DELEGATED HOUSEHOLDER DECISION

Item No. Report of the Head of Development Management and Building Control**Address:** 15 RUSHDENE ROAD EASTCOTE**Development:** Erection of rear canopy past the rear extension.**LBH Ref Nos:** 63838/APP/2025/1660**Drawing Nos:** RR PP 02 REV B
RR PP 04 REV C
RR PP 03 REV B**Date Plans received:** 16-06-25**Date(s) of Amendments(s):****Date Application valid** 18-07-25**1. CONSIDERATIONS****1.1 Site and Locality**

No.	Date	By	Contents
Revisions			
Drawing Title			
Location Plan & Site Plan			
Project			
Replacement rear canopy			
Scale	Date	Drawn by	
As stated	March 2025	SD	
Client Details			
Mrs Kamini Thayalanayagam 15 Rushdene Road Eastcote Hillingdon HA5 1SW			
Drg.No.	RR PP 02	Rev.	B

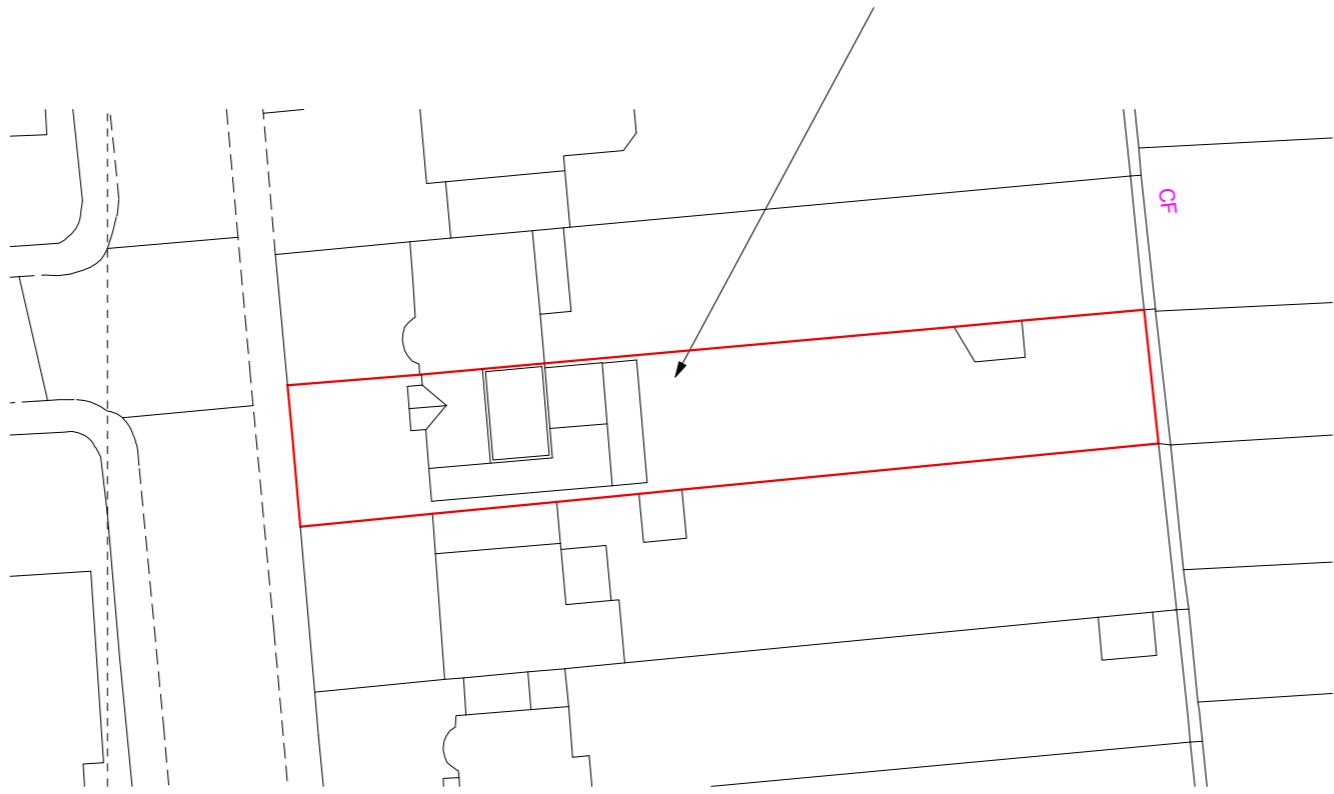
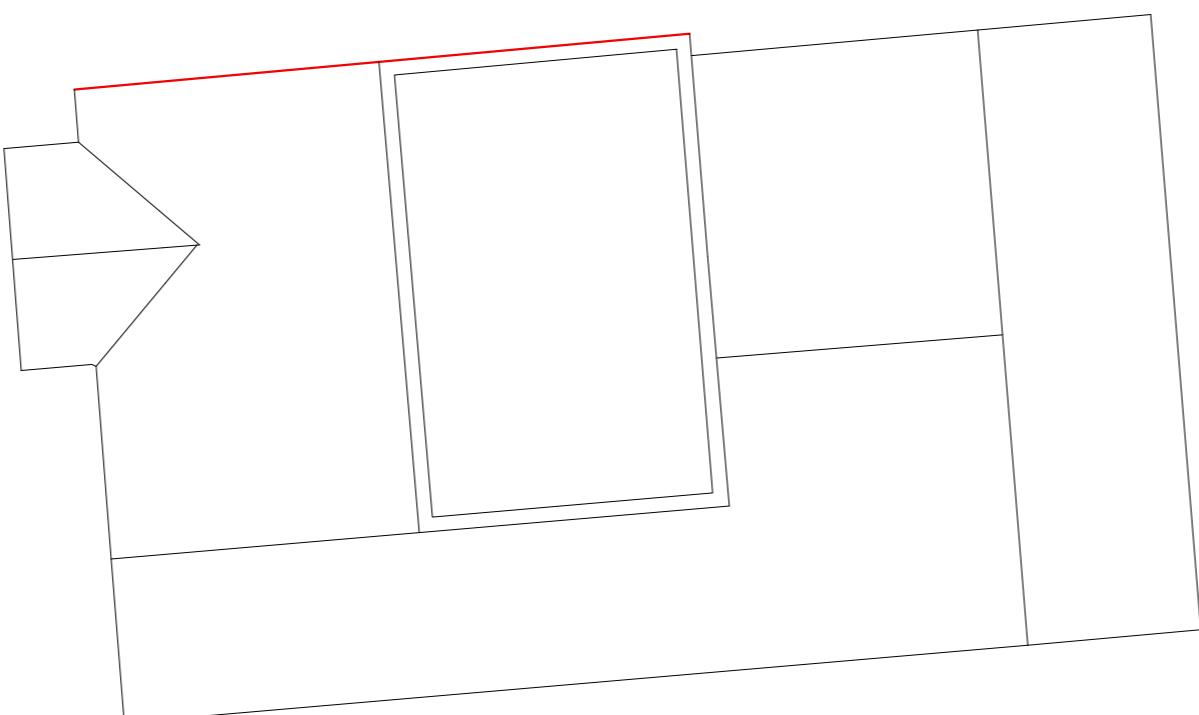
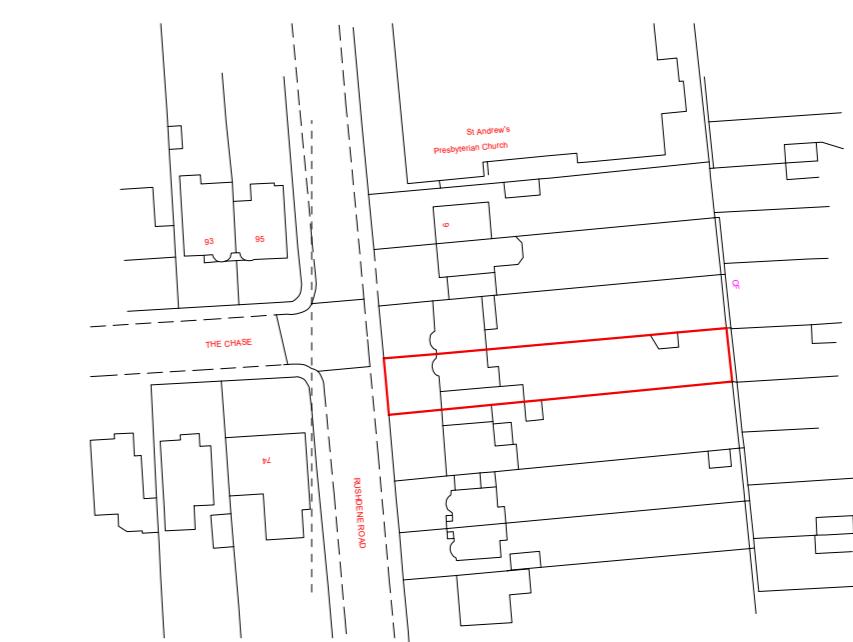
A rear canopy would be erected and attached to the approved single-storey rear extension. The submitted plans demonstrate that the canopy is 2.25m deep and approximately 2.5m high, which matches the height of the approved single-storey rear extension, when measured from the lowest part of the eaves. The canopy is constructed of timber posts along the side and a plastic/perspex-style translucent roof with a flat roof.

The difference between this scheme and the previous scheme is that the pitched roof element has been omitted and the scheme now proposes a flat roof just below the eaves of the existing extension. The depth of both the extension and the canopy would amount to approximately 6m which is over and above the allowance within the Development Management Policies which allows rear projections of 3.6m. The use of a plastic translucent style roof and timber posts would add to the discordant nature of the development. It would appear at complete odds with the main materials of the dwelling house and would lead to a detrimental visual impact on both the main house and the wider local character.

Whilst it is acknowledged that the structure is not readily visible from the street scene, it nonetheless appears as a highly conspicuous form of development when viewed from the rear gardens of neighbouring properties and is not supported. The overall depth, scale and poor design would lead to a discordant addition to the rear of the properties.

The planning officer notes that the canopy is now lower in height however this does not overcome the appeal concerns. The overall depth and materials used in the finishes remained at the heart of the appeal decision. Whilst the height would slightly reduce the visual impact, the relationship of the flat roof (with its plastic material) partially enclosing the rear extension would remain discordant in design to the detriment of the local character. The proposed materials and additional depth are not supported; the rear canopy would be considered unacceptable on the basis that the scheme although has been reduced significantly, would not be of high calibre and is therefore contrary to Policy DMHD1 and DMHD 11 whereby schemes must be designed to a high quality.
